13 October 2021

Re: St John of God Richmond Hospital Redevelopment (SSD-10394) Response to Submissions

09 GARDEN PAVILION  
SCALE: 1:200

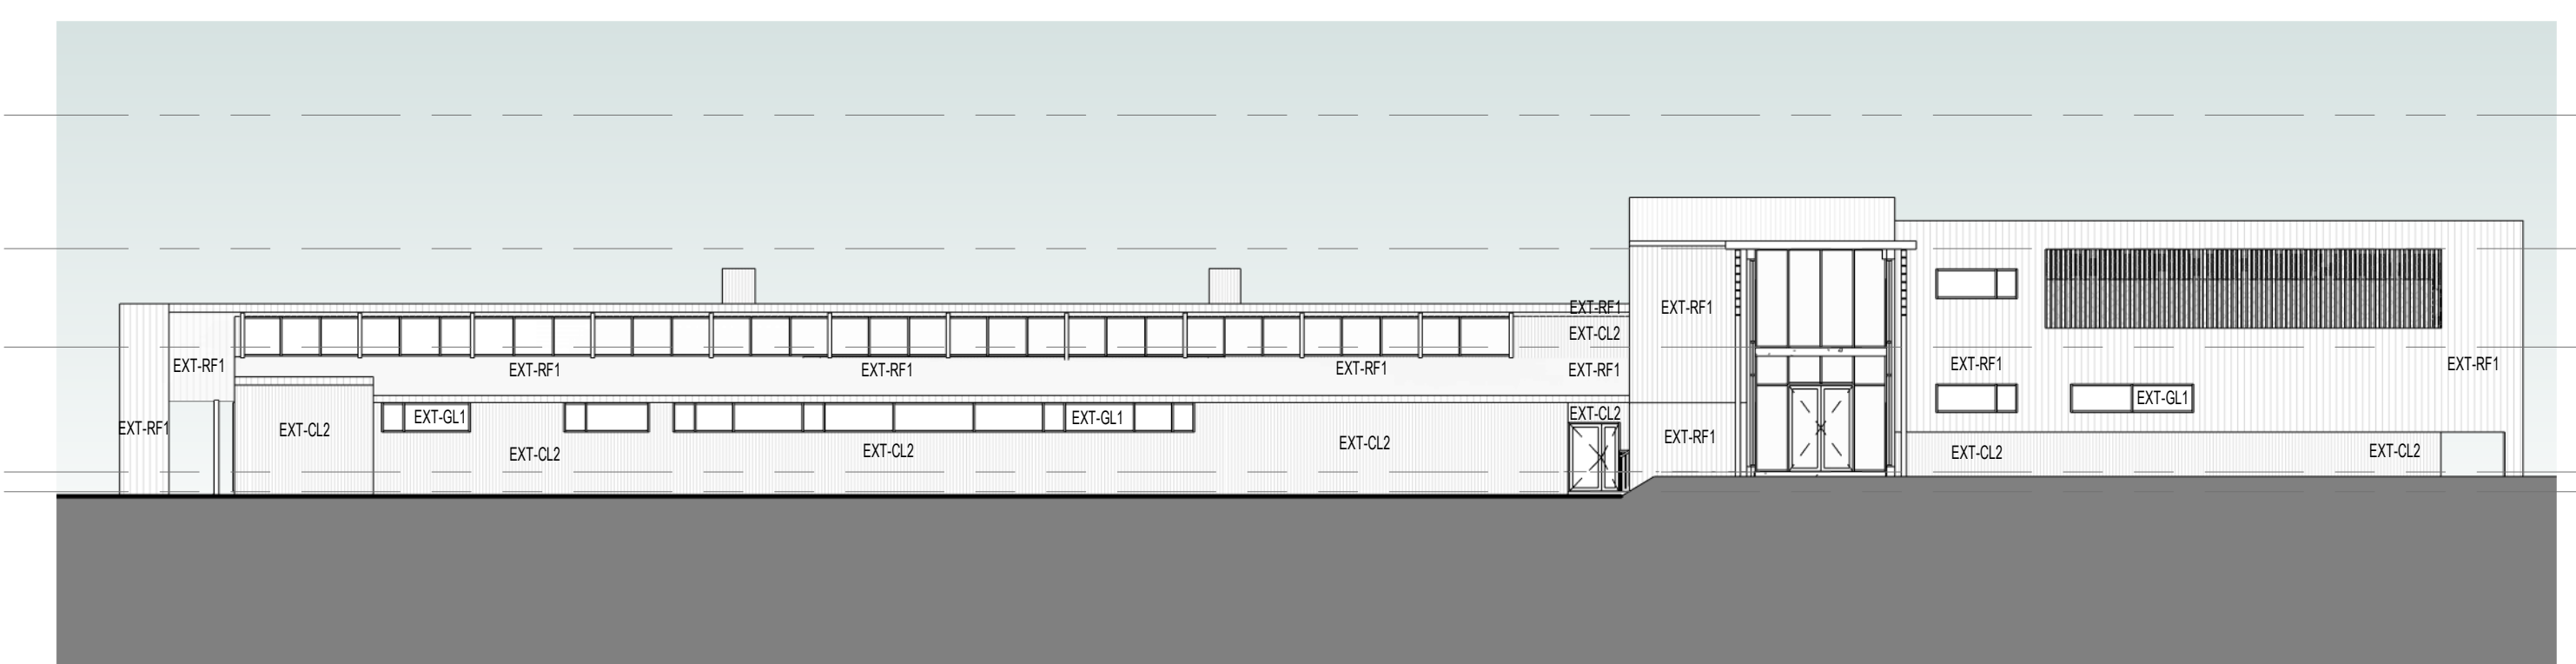
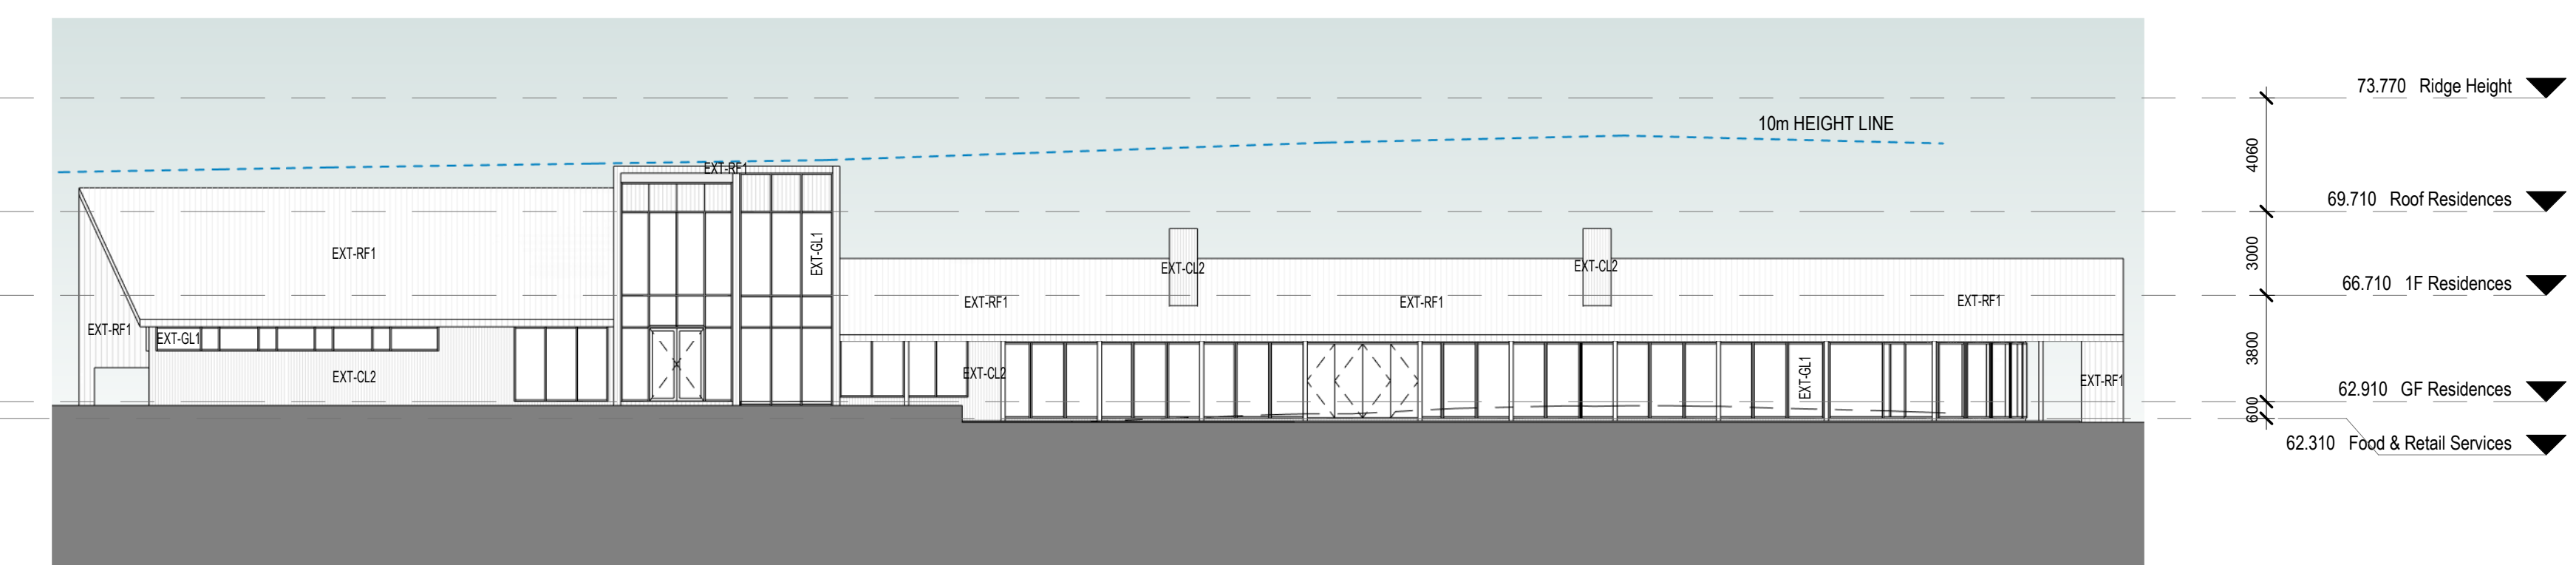
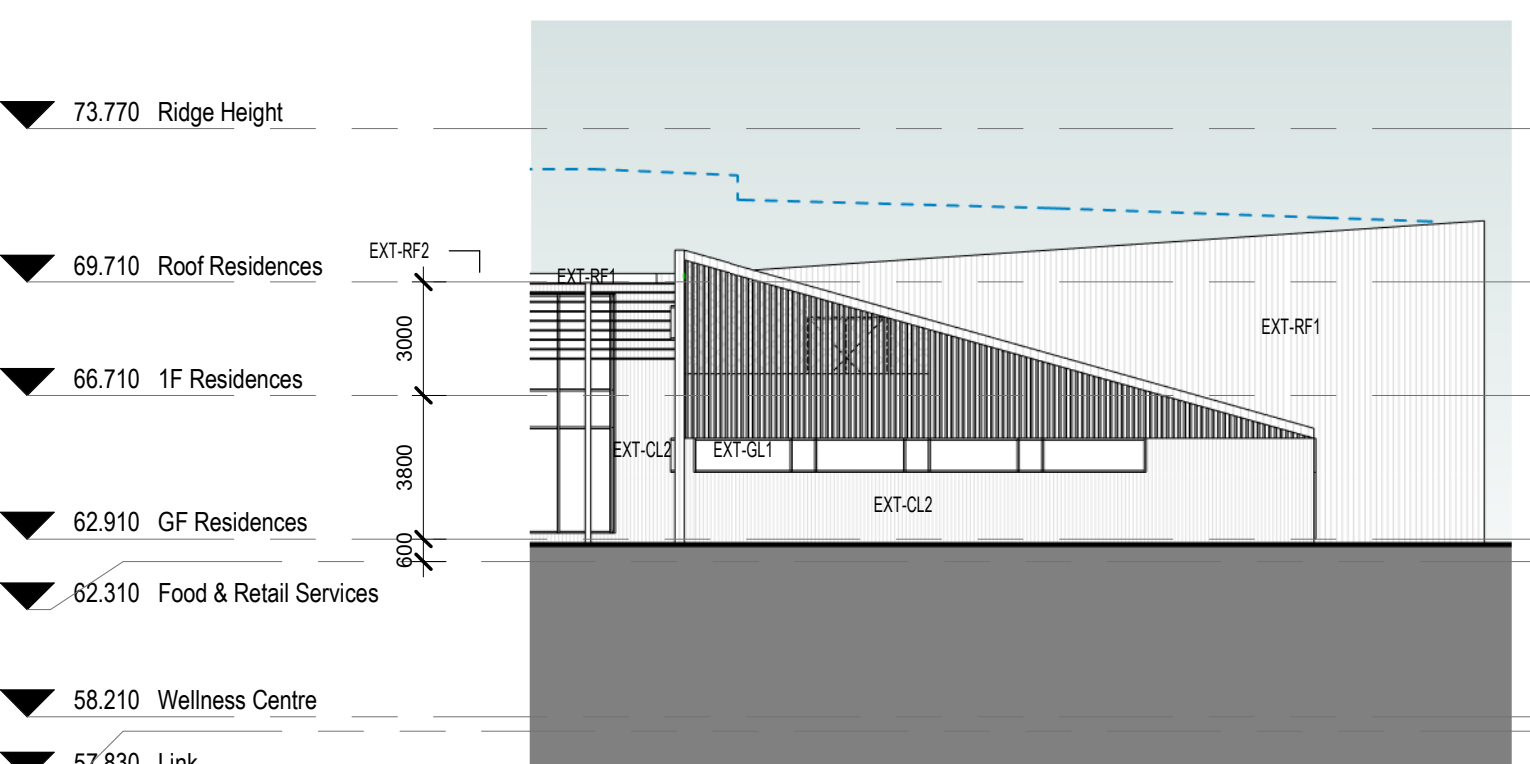
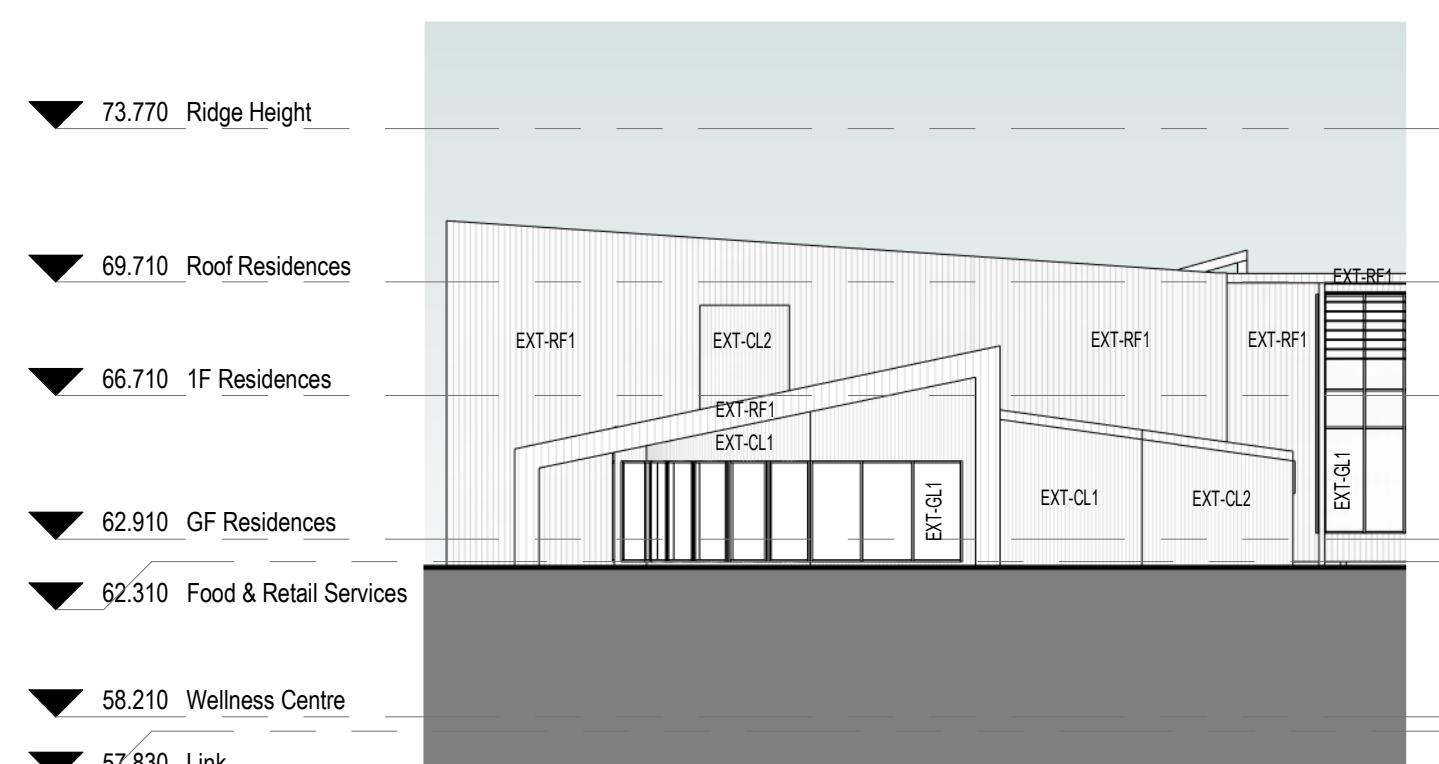
- 1. the architectural plans are to be updated demonstrating that the proposed buildings are constructed to BAL-FZ. As the Garden Pavilion is attached to the Residential Pavilions, PBP 2019 does not allow any downgrade of Bushfire Attack Level (BAL) when any part of the building is situated within BAL-FZ. For this reason all new construction is to be in compliance with Section 3 and Section 9 (BAL-FZ) of Australian Standard 3959:2018 Construction of buildings in bushfire areas.***

Similarly, the Garden Pavilion is significantly removed from the low bushfire risk and is within BAL 12.5 as demonstrated in the BHA. The condition to unduly require this building to be upgraded 4 BAL levels above the actual BAL is unreasonable and not in keeping with PBP or AS3959.

The safe refuge is provided within the Garden Pavilion which is at BAL 12.5 (see Appendix 1) in accordance with the determined BAL levels for the building.

The dining area which is intended to be used as the refuge will be fire isolated with in a two hour fire rated compartment and therefore fire separated from the remainder of the building.
